A303 Sparkford to Ilchester Dualling Scheme TR010036

8.6 Statement of Common Ground with Somerset Drainage Board Consortium

STATEMENT OF COMMON GROUND

Regulation Number:	Regulation 5(2)(q)
Planning Inspectorate Scheme Reference	TR010036
Application Document Reference	8.6
Author:	A303 Sparkford to Ilchester Dualling Scheme Project Team, Highways England

2.11 Outline Drainage Works Plans

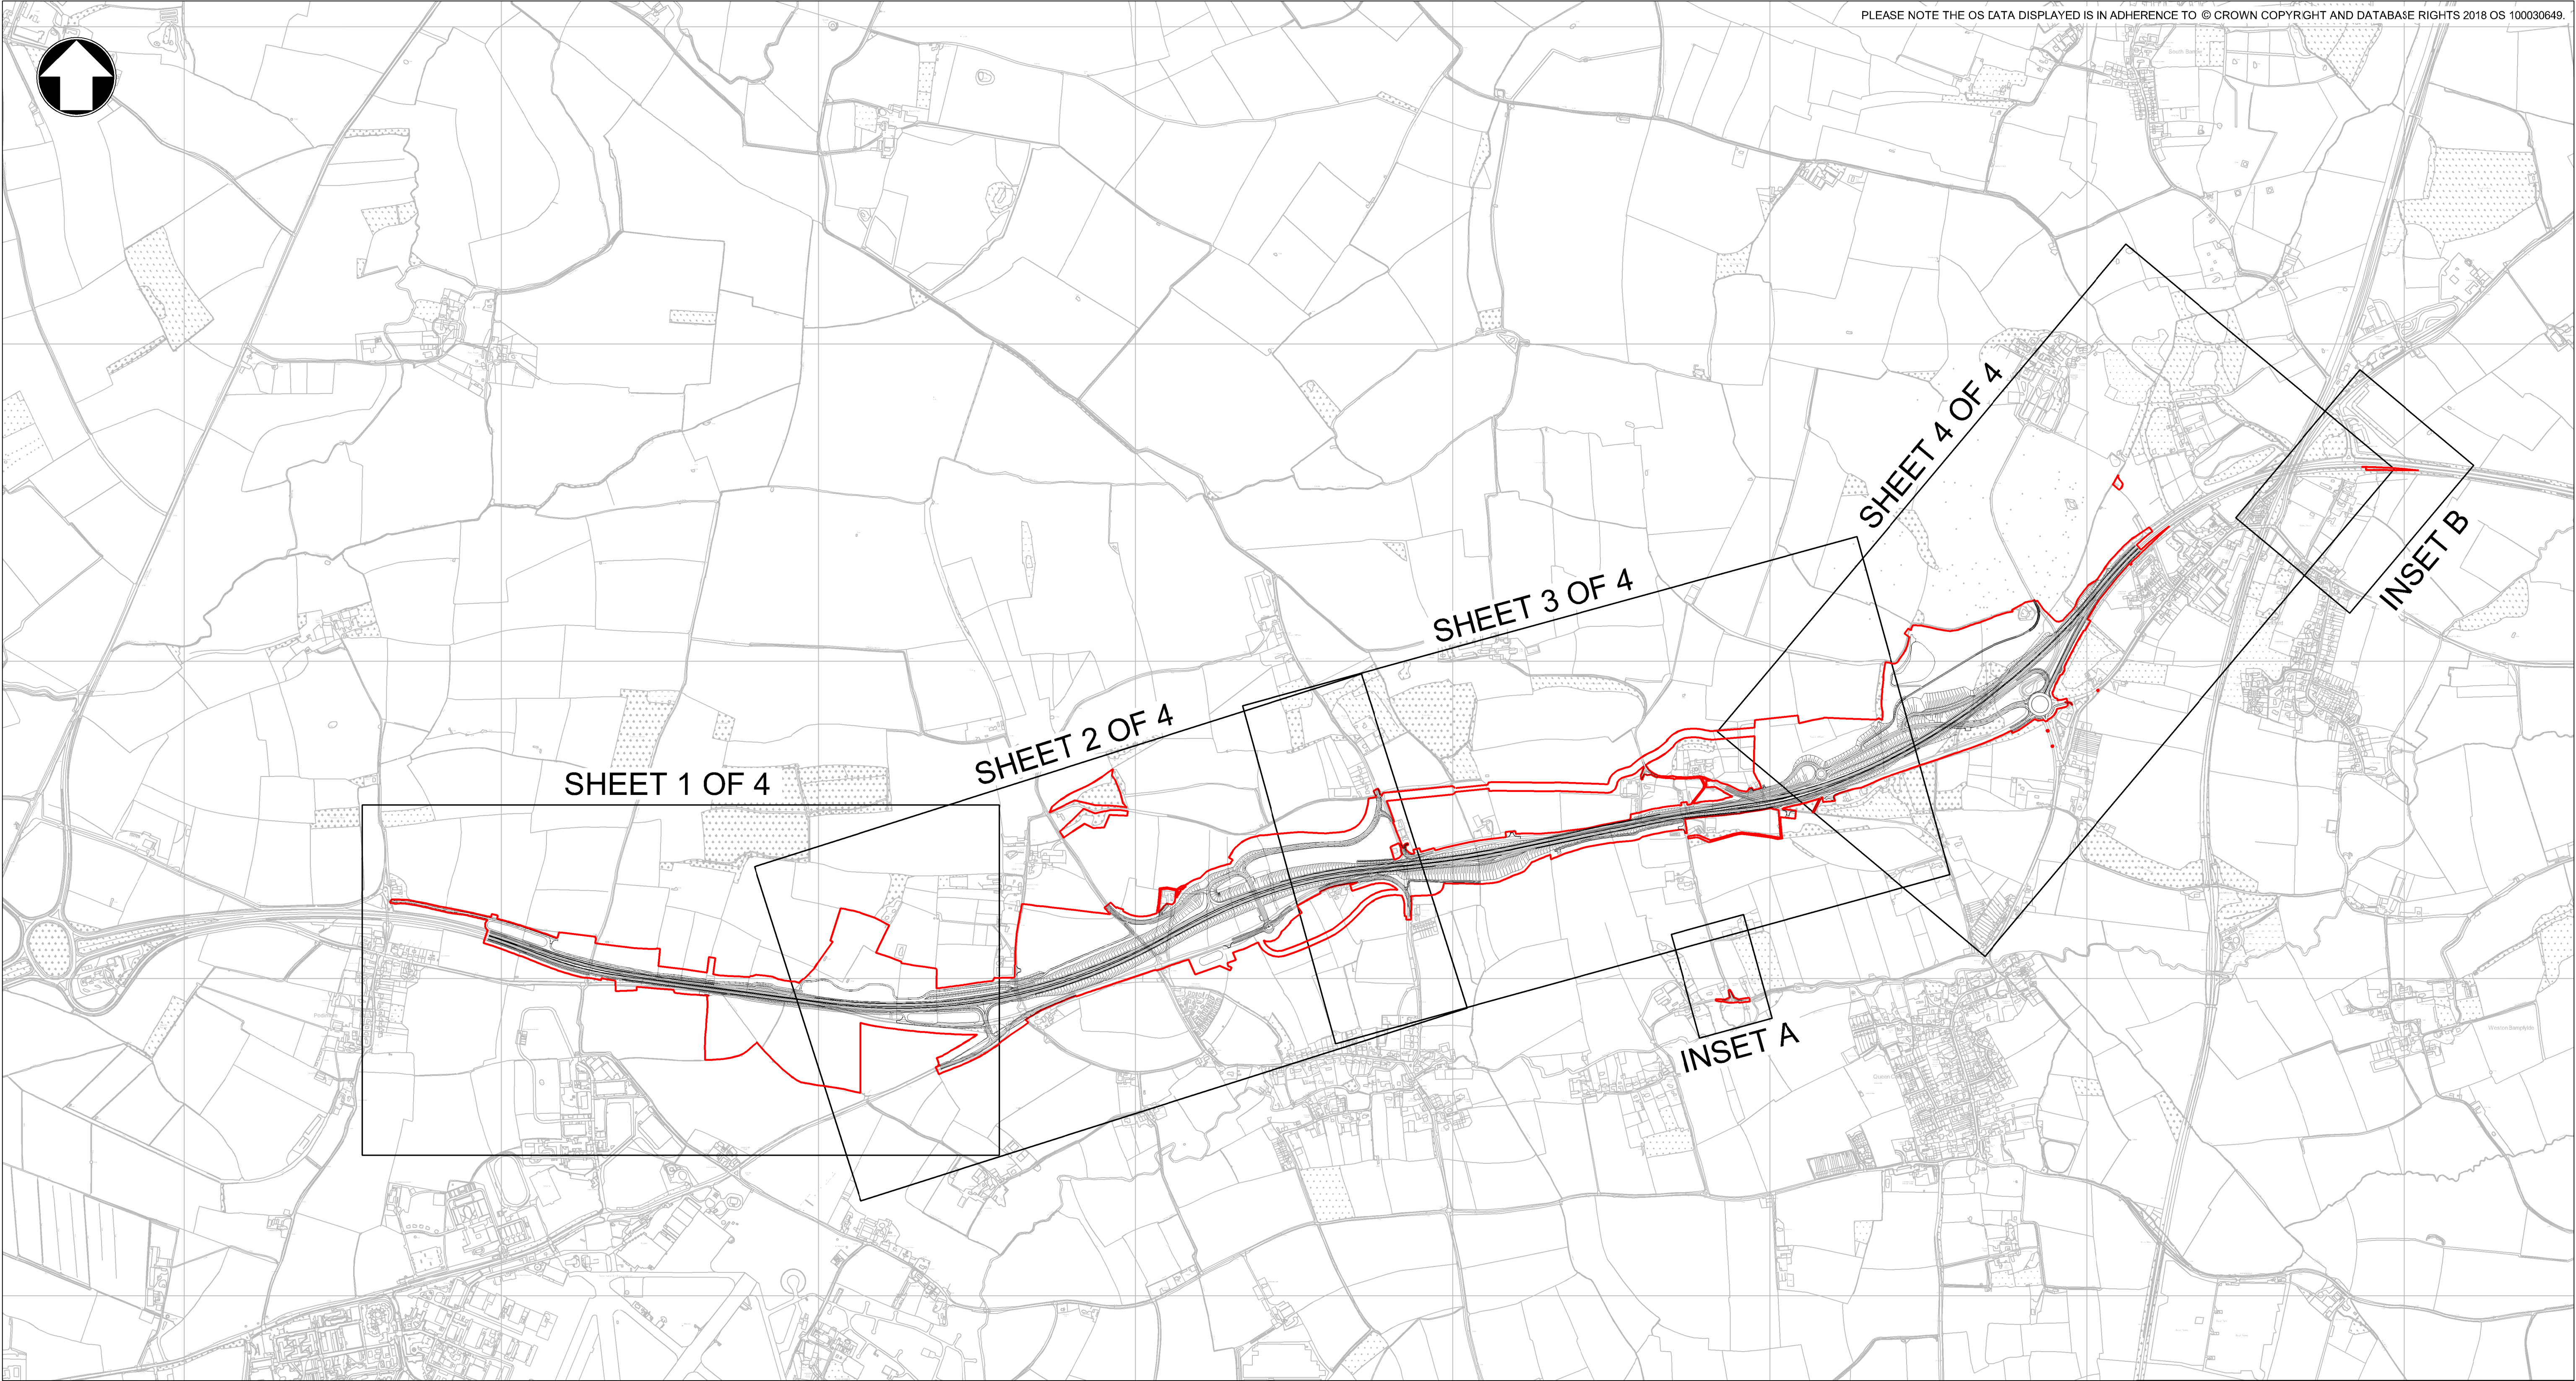
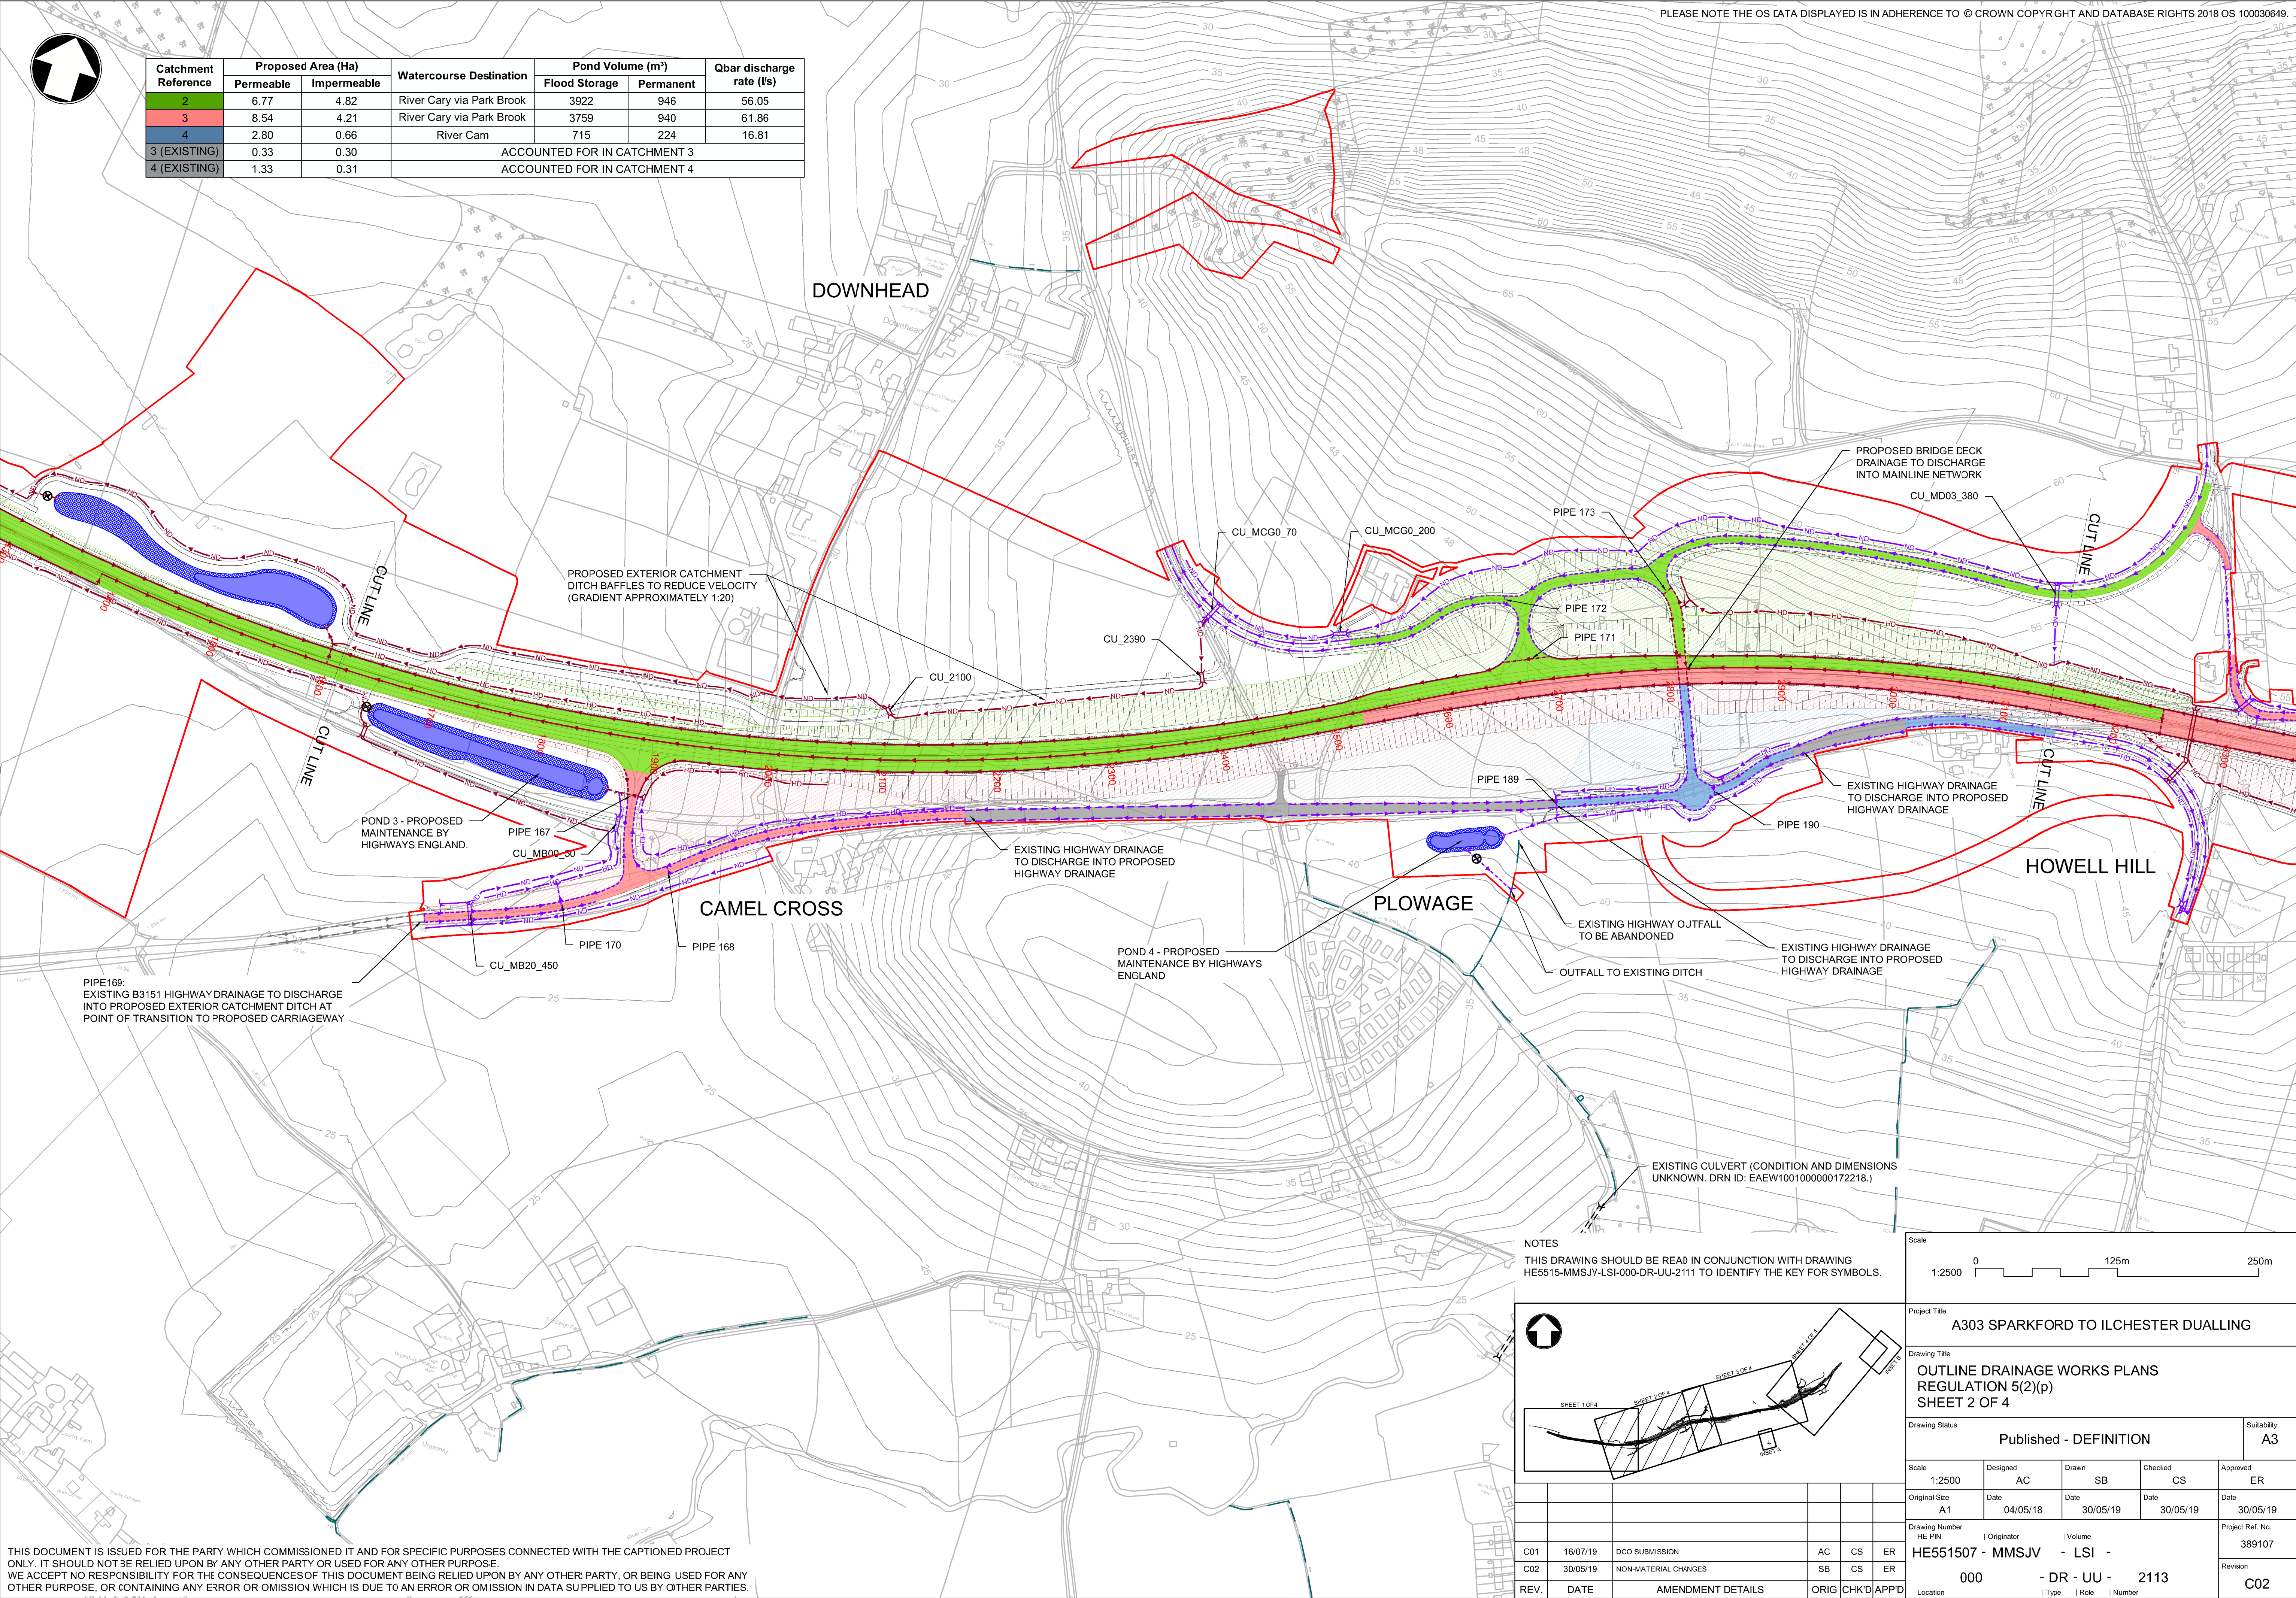
Topic	Stakeholder Comment	Highways England Response	Status
Water quantity	Confirmation is sought that the proposed design will control the overall volume, as well as the overall rate of runoff with sufficient attenuation provided.	Attenuation has been provided, with discharge limited to 1% annual exceedance probability (1 in 100-year event) plus 40% to account for the effects of climate change (Flood risk assessments: climate change allowances, Environment Agency), to no greater than the undeveloped rate of runoff, determined by the calculation of the mean annual peak rate of runoff for a greenfield site (Qbar). Preliminary design discharge rates and volumes shown in Outline Drainage Works Plans (document reference, TR010036/APP/2.11).	Agreed
Water quality	Confirmation is sought that the proposed pond design provides effective water quality treatment with the use of a permanent water level, and that this volume is sufficient in size. It is recommended that the SuDS Manual (C753) is referred to in the calculation of these permanent volumes, as well as the detailed design of the forebays and vegetation that will be essential for water treatment.	A permanent water level has been provided for each of the proposed ponds. The volume of treatment has been provided in accordance with the SuDS Manual (C753), i.e. '10-15mm of rainfall depth falling over the contributing catchment'. Accepted. Appropriate planting has been considered as part of the landscaping assessment and design. Attenuation feature discharge rates and volumes shown in Outline Drainage Works Plans (document reference, TR010036/APP/2.11).	Agreed

The use of grassed surface water channels is supported. Confirmation is sought to where	Grassed line channels have been incorporated where the carriageway is in cutting.	Agreed

There is concern that the maintenance tracks do not provide access to the control structures, which would need to be maintained and accessed in the event of a large pollution incident.	Accepted. The ponds and maintenance tracks have been redesigned to provide access to these structures. Access shown in Outline Drainage Works Plans (document reference, TR010036/APP/2.11).	Agreed
Existing watercourses and structures	There is concern for the condition of the existing watercourse that the existing A303 drains into, with known issues with some of the existing culverts. It is recommended that the condition and capacity of the flow route from the proposed outfalls are checked until the flow reaches a main river or watercourse, maintained by an	Accepted The proposed scheme utilises the existing outfall locations. Through implementation of the proposed drainage strategy the rate of discharge will be limited creating a betterment. It is noted that a condition survey has not yet been undertaken and this will be undertaken at subsequent design stages.	Agreed
